Romaldkirk Parish Council
c/o The Rectory
Romaldkirk
Barnard Castle
Co Durham

Date: 22 January 2021

RE: Planning Application: DM/21/00002/LB | Listed Building application for installation of CCTV equipment, 2no raised deck areas to front garden and erection of detached exercise room to rear garden (retrospective) | Rose Stile Cottage Sennings Lane Romaldkirk Barnard Castle DL12 9ED

ROSE STILE COTTAGE
 ROMALDKIRK
 PROPOSED EXERCISE ROOM
 SCALE 1:50 AUGUST 2020

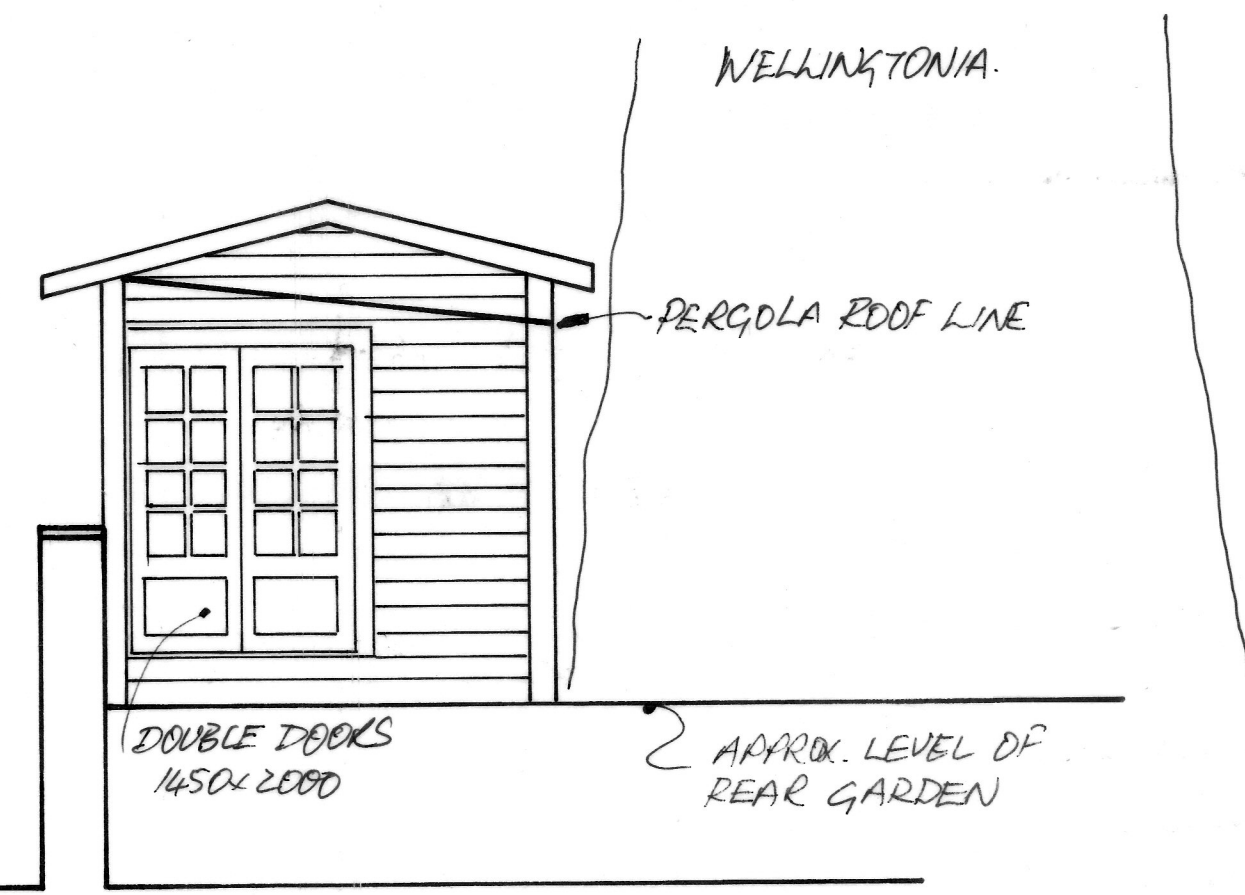
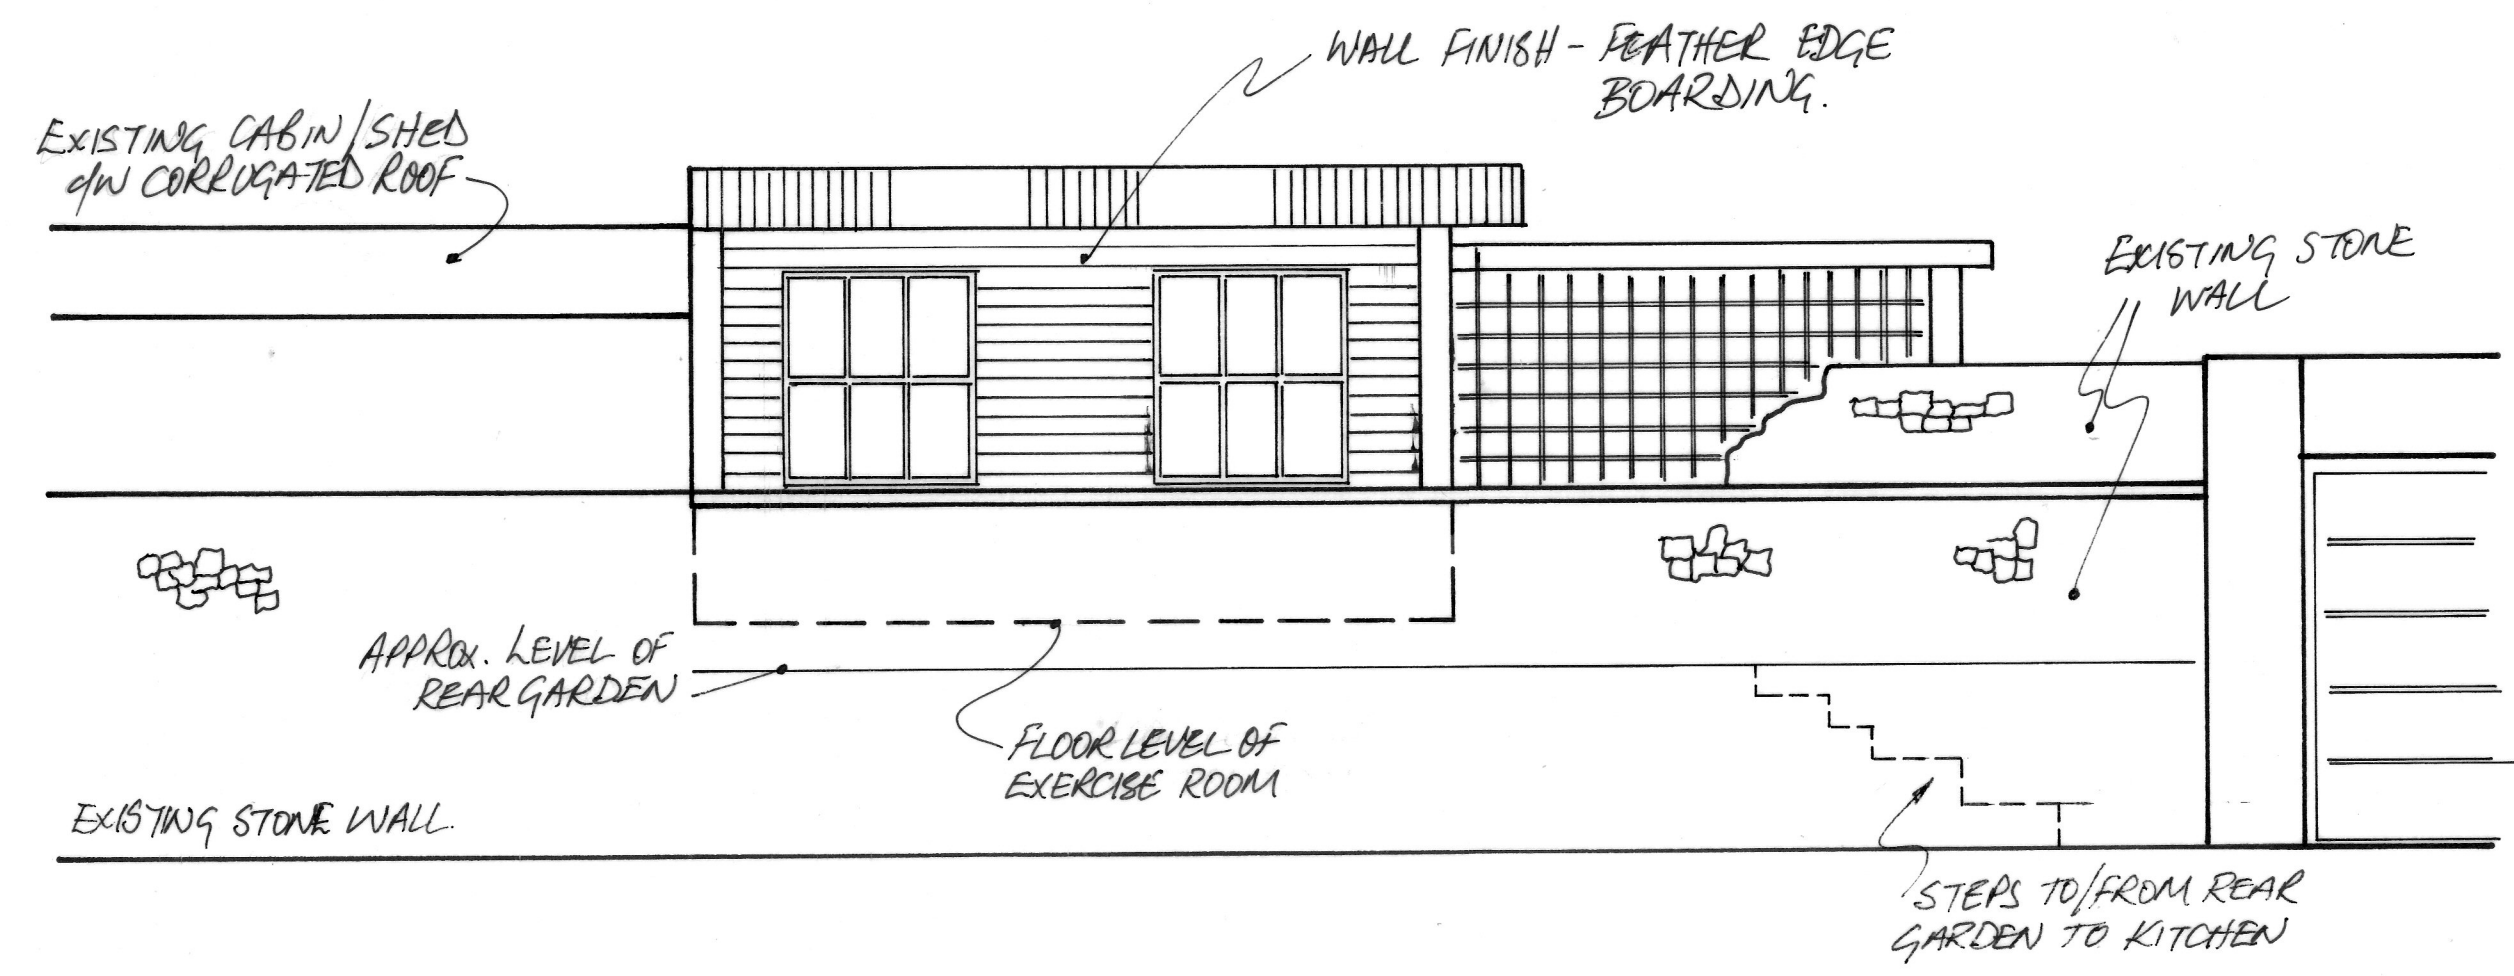
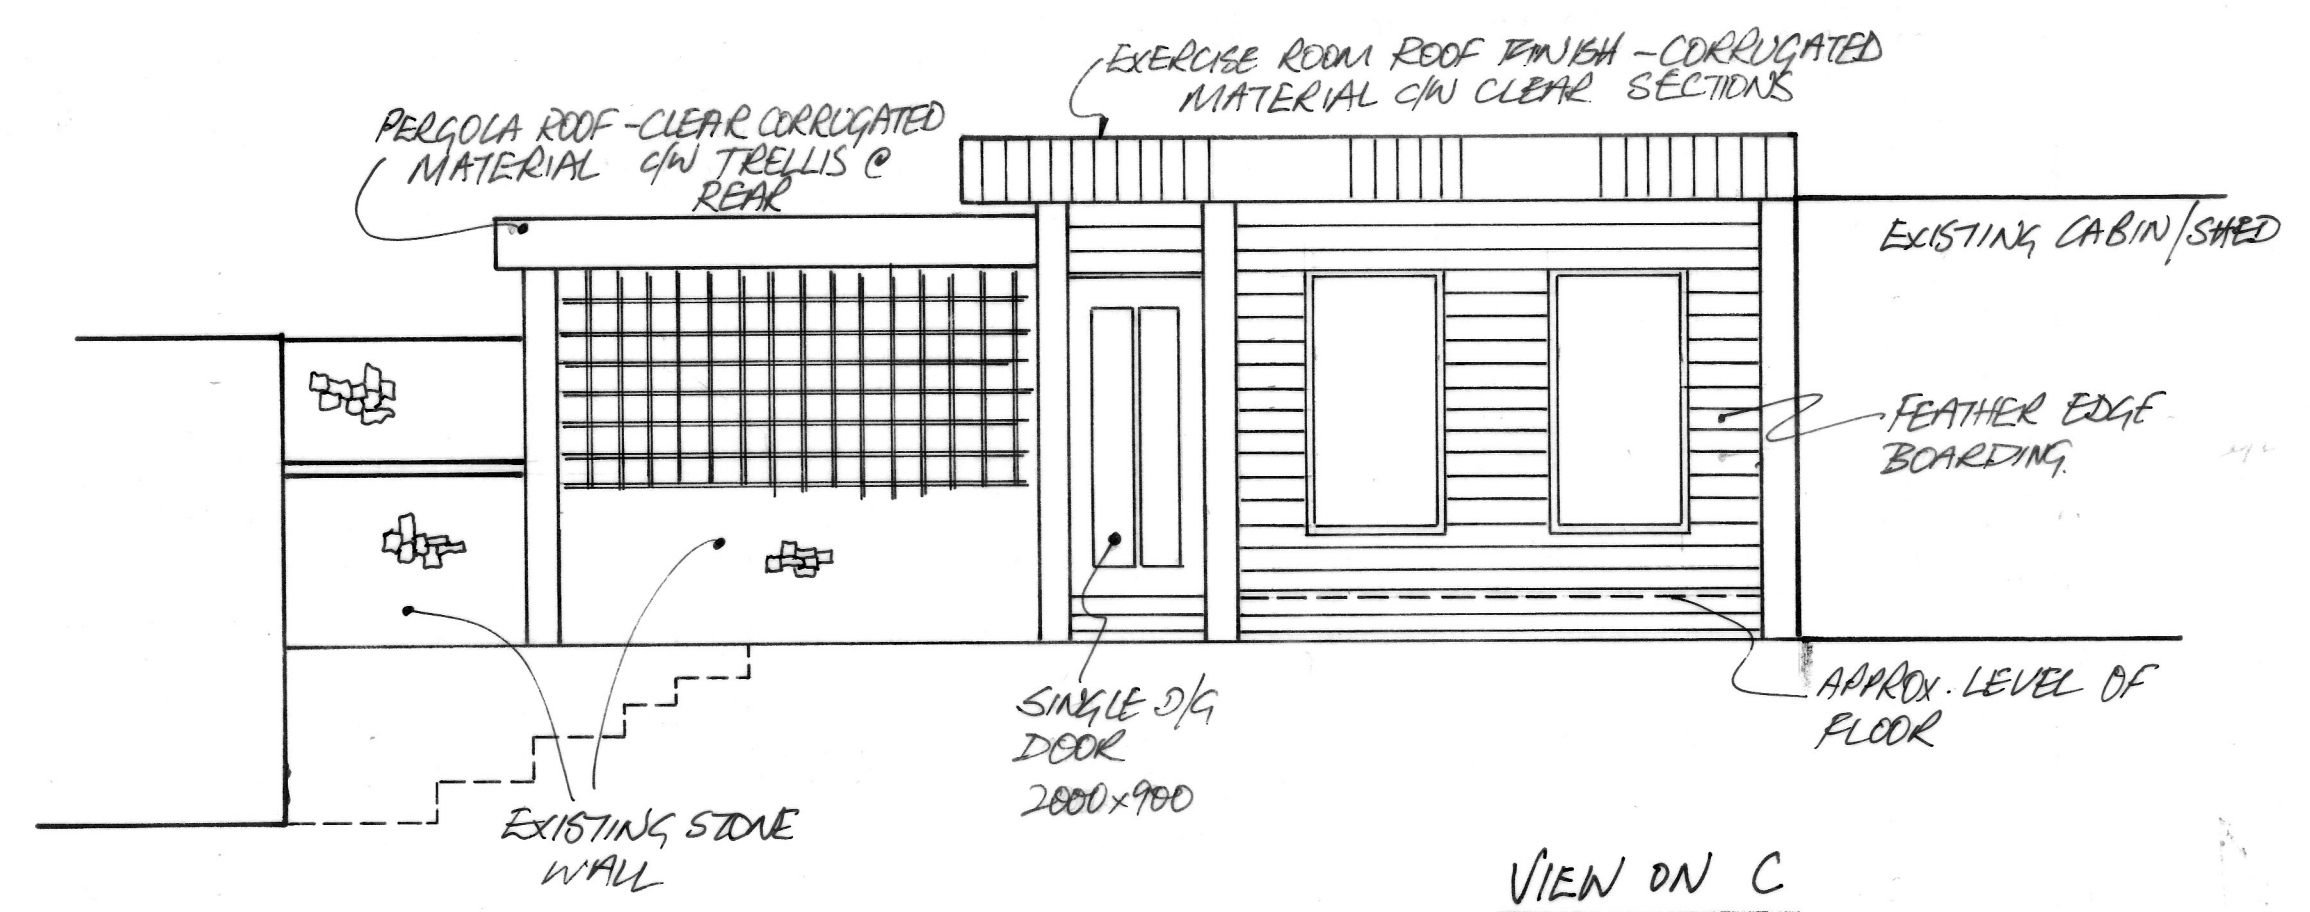
The exercise room and pergola will abut the stone boundary wall adjacent to Sennings Lane. This lane is a well-used public right of way which contributes greatly to the character and appearance of Romaldkirk conservation area. The area proposed for development also being visible from the Low Green area of the Village.

There exists a disparity in site levels between Sennings Lane and the rear garden at Rose Stile Cottage, with the garden of Rose Stile Cottage sitting at least 1m above Sennings Lane. Due to this disparity and the design of the proposed building, the exercise room would be visually dominant when viewed from Sennings Lane and will therefore adversely impact on the visual

character and appearance of the listed stone boundary wall and surrounding conservation area. This impact will be particularly stark given the proposed materials, a point addressed below.

The plans for the 'exercise room' propose windows on the east elevation which will sit significantly higher than the stone boundary wall and therefore will overlook Sennings Lane. This lane is currently characterised by stone boundary walls, creating a feeling of privacy and seclusion. The introduction of the windows abutting the wall and overlooking the lane will have a significantly adverse effect the character and appearance of this historic track and its surroundings.

Having given regard to the materials proposed for use in the building, it is clear they are wholly inappropriate for a listed building and the conservation area. It is noted that there is an existing corrugated metal roof on the kitchen, however it is not clear from researching the planning history whether this was approved in previous applications.

Nevertheless, this should not set a precedent within the site or the wider conservation area, to allow further unacceptable materials to be used to the detriment of the existing building. Given the scale and prominence of the exercise room, the use of the proposed materials will most certainly detract from the character and appearance of the conservation area and the merit of the listed building.

Also of significant concern is the continuous line of development the allowing of this proposal would create. In this instance the proposal would create a solid line of development extending from the front elevation of the property to the rear boundary which is approximately 36 meters running along the boundary with Sennings Lane, creating a visual effect which is clearly incongruous with, and damaging to, both the listed building and the conservation area.
